DEVELOPMENT CONSENT ORDER (DCO), SIZEWELL
East Anglia Two (EA2) and East Anglia One North (EA1N) Proposals

This letter covers the response to the submitted DCOs for and on behalf of NGL, which is the owner and operator of SZB nuclear power station. A separate letter covers the response on behalf of SZC. NGL recognises the importance of the SPR off-shore wind proposals and has no objection to the principle of the proposed wind farms and associated off-shore and on-shore infrastructure. However, as SZB is an operating nuclear power station there are a number of important considerations, set out below, which need to be addressed.

Coralline Crag

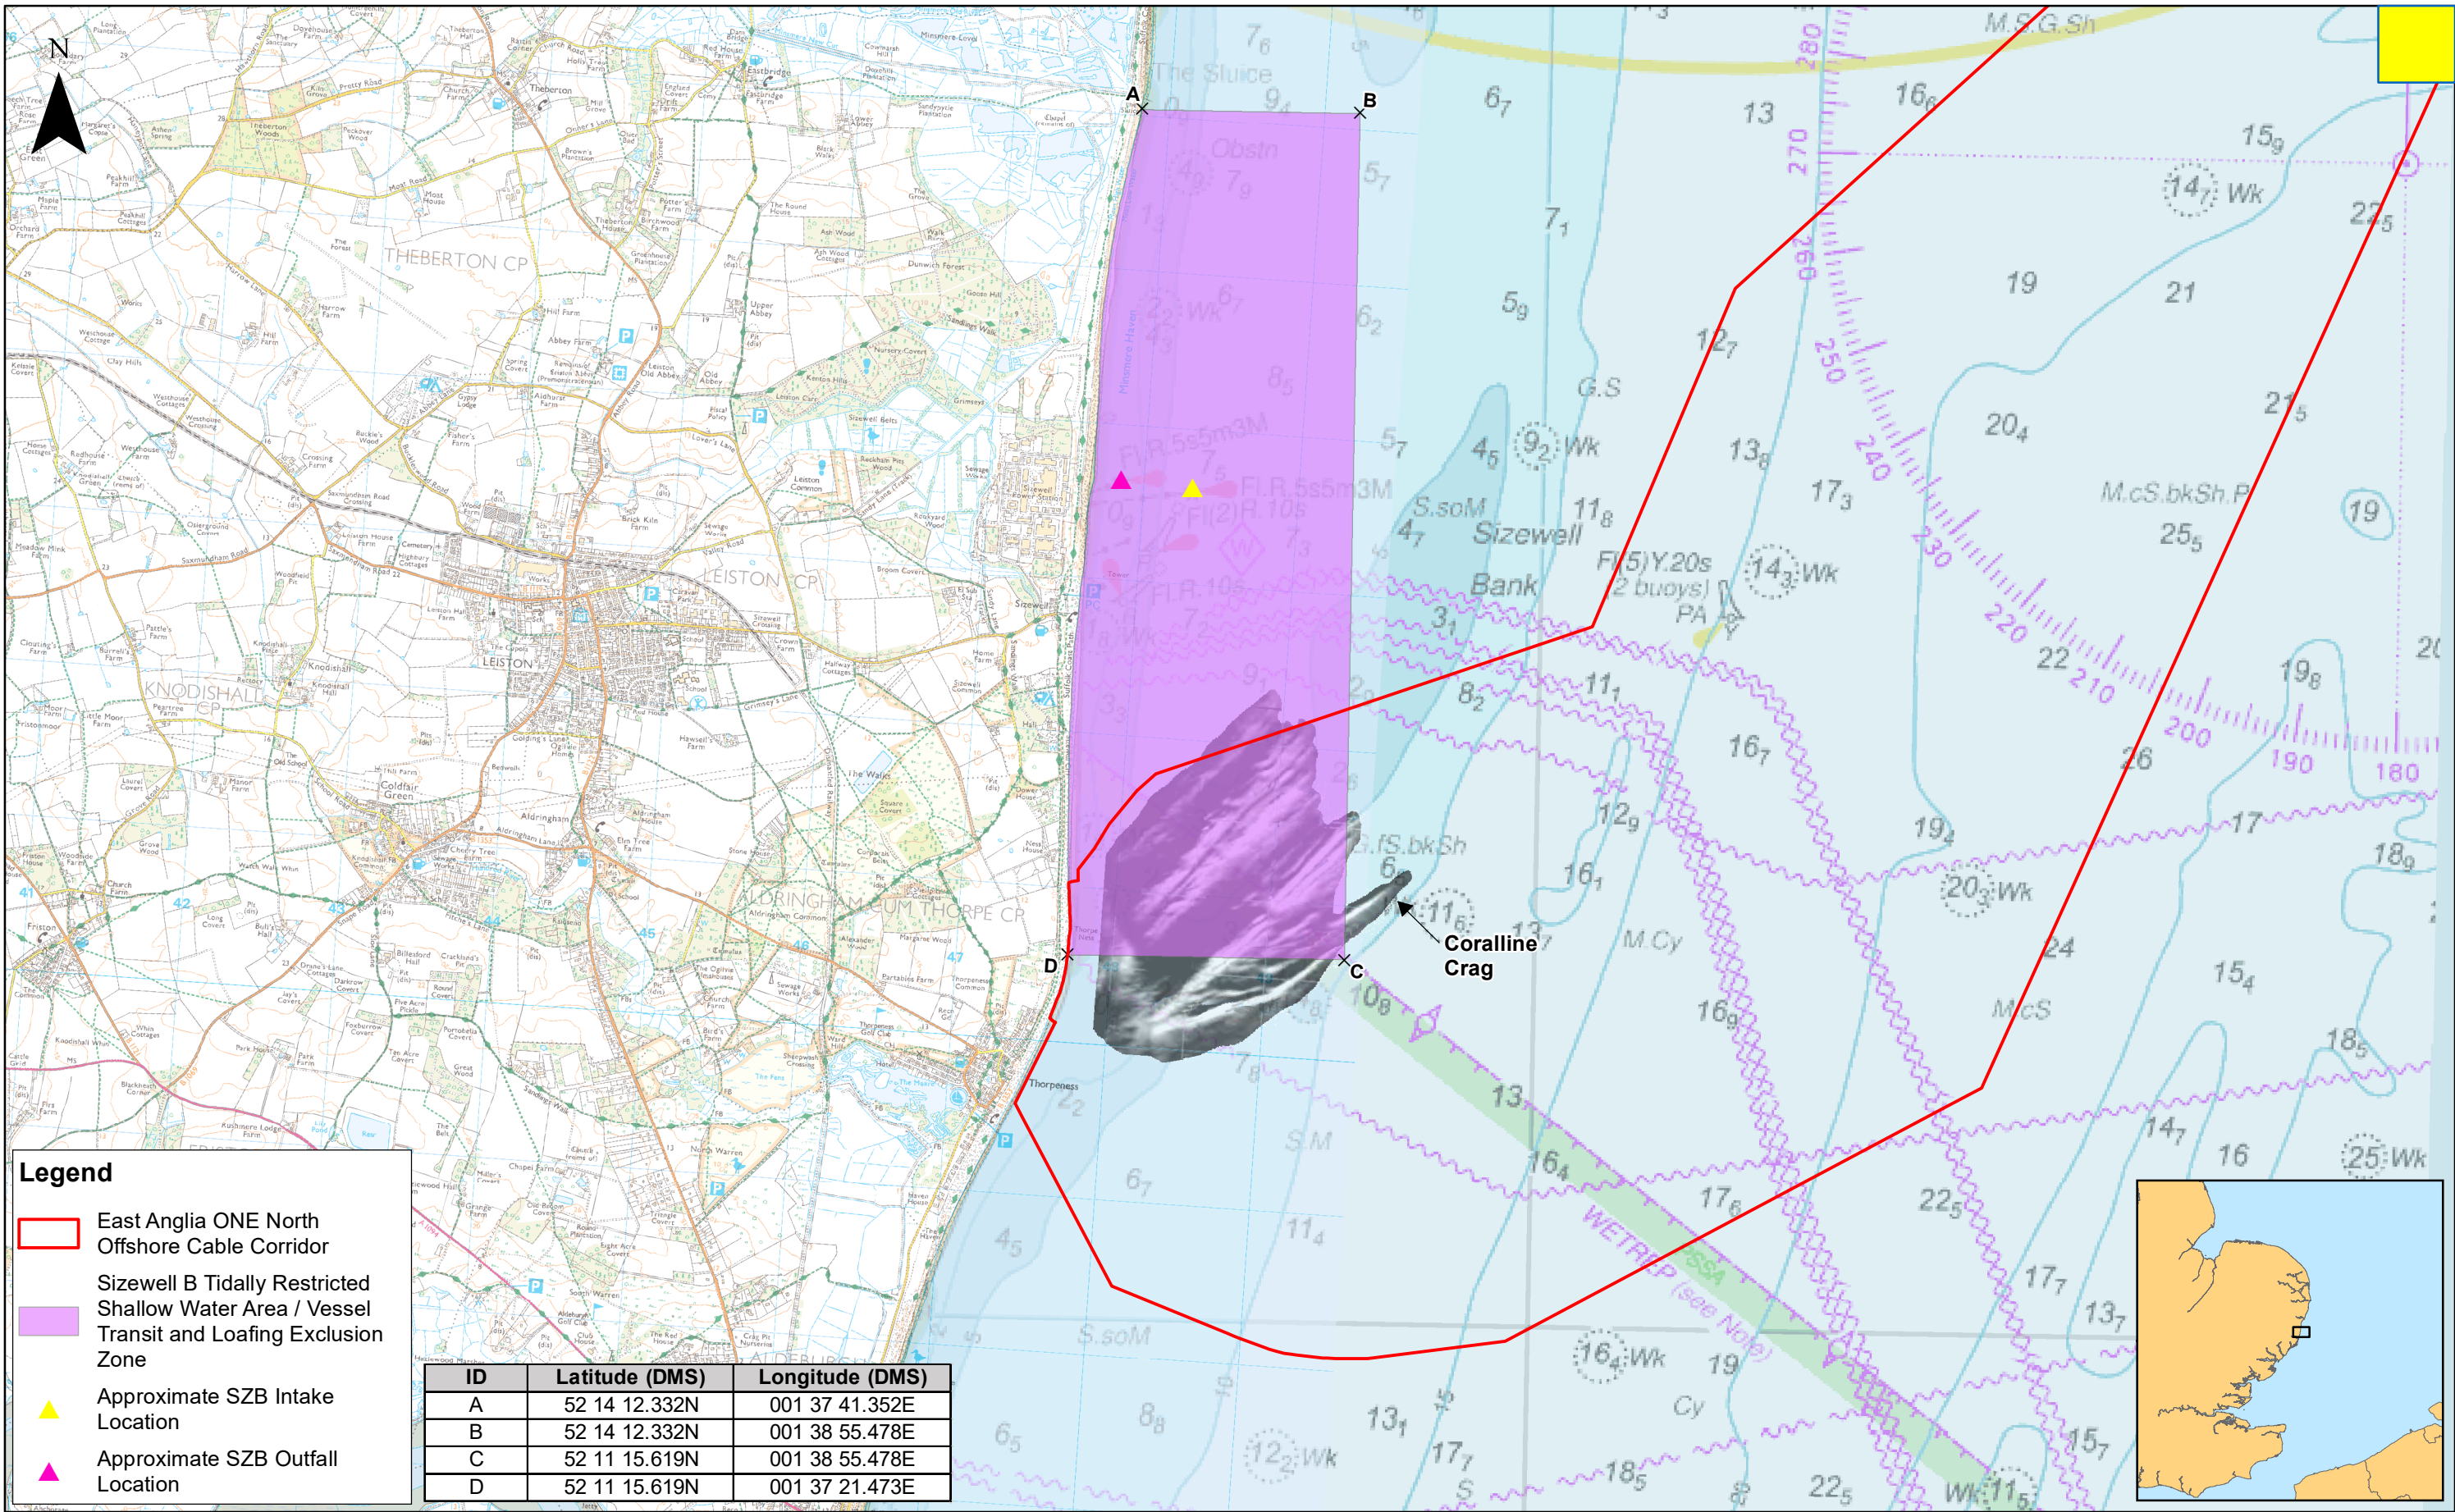
The SPR cable corridor includes within it the majority of the Coraline Crag formation (calcareous sand rock outcrops). In relation to the continued safe operation of SZB, NGL are particularly concerned that the protection afforded to the Sizewell shore by the Coraline Crag between Sizewell and Thorpeness should not be compromised. SPR have been made aware by NGL of the need to avoid potential disturbance to the Coraline Crag and associated seabed morphologies when considering actual cable routes, cable laying methodologies and subsequent maintenance requirements. Protective Provisions should be included in the SPR DCO to ensure that, after SPR have carried out their detailed pre-construction surveys to determine the southern extent of the Coraline Crag formation, this is achieved in practice.

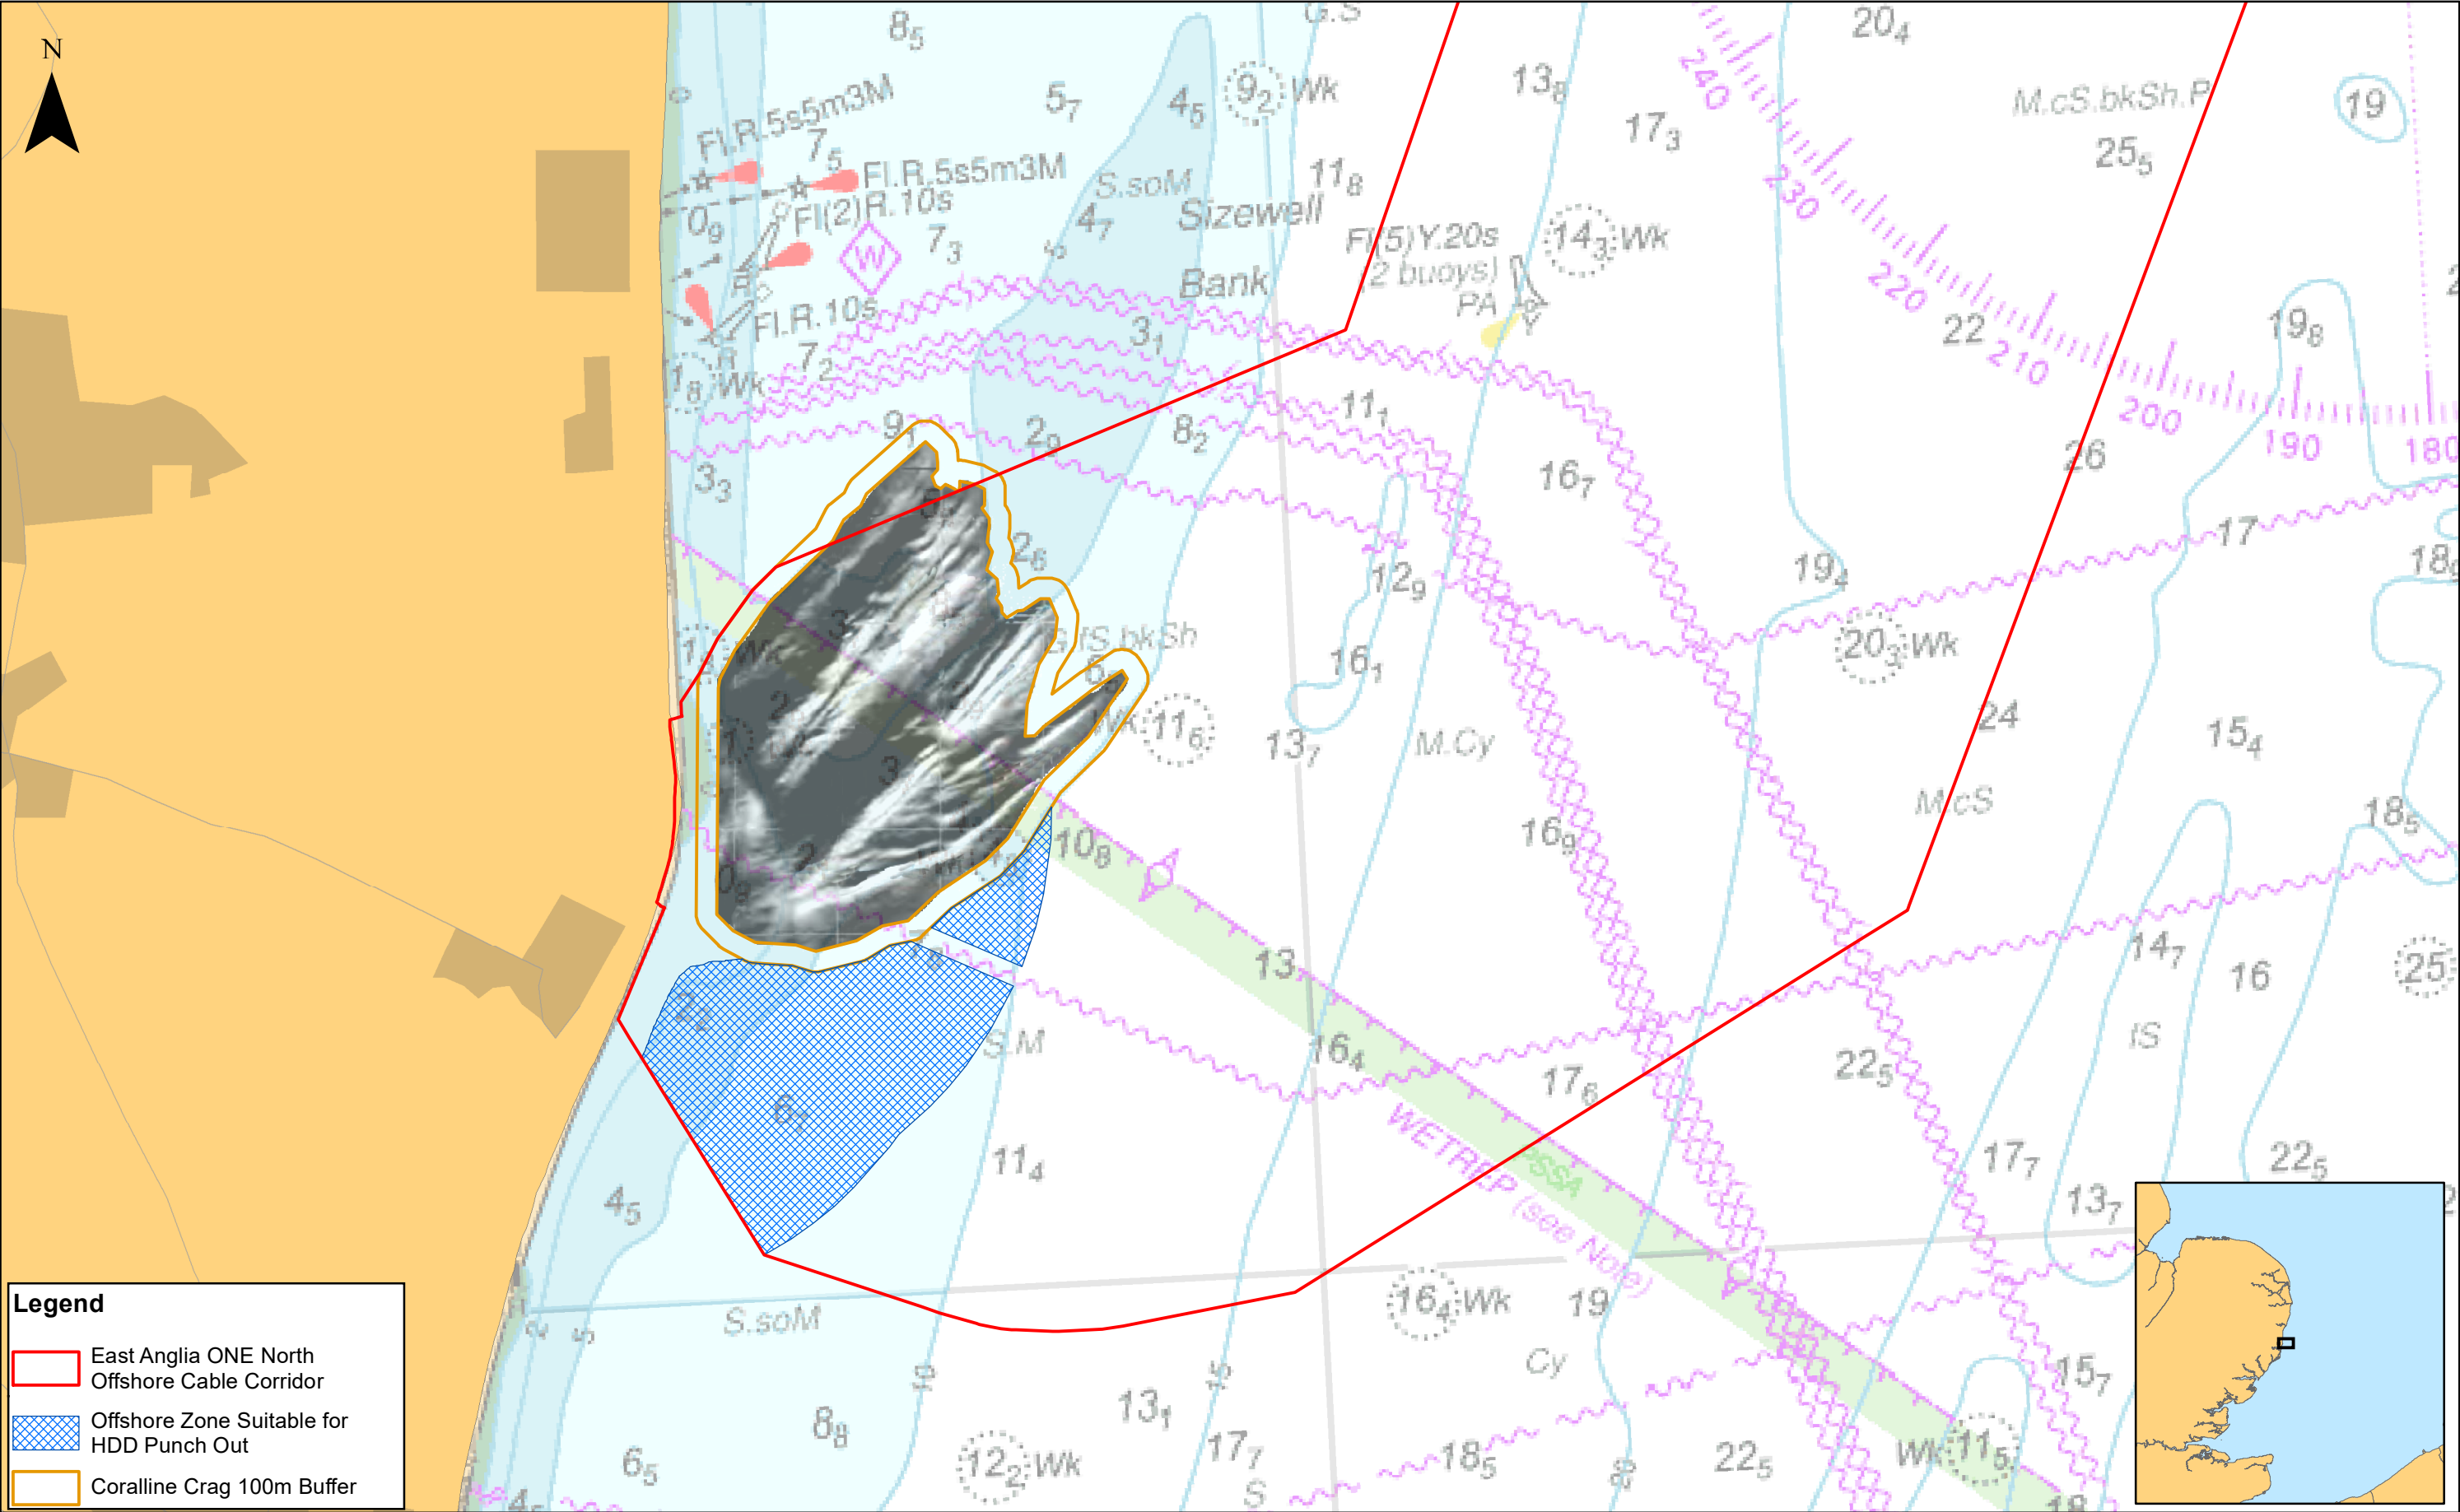
The proposed SPR export cables would pass to the east of the existing SZB and proposed SZC offshore cooling water structures, before crossing the line of the Greater Gabbard and Galloper cables, turning to the west and making landfall to the north of Thorpeness. As a consequence, marine issues previously raised by us (with reference to SZB and SZC) in connection with the Galloper Wind Farm Project are also relevant here, with the added complexity that the Galloper cables are now in situ.
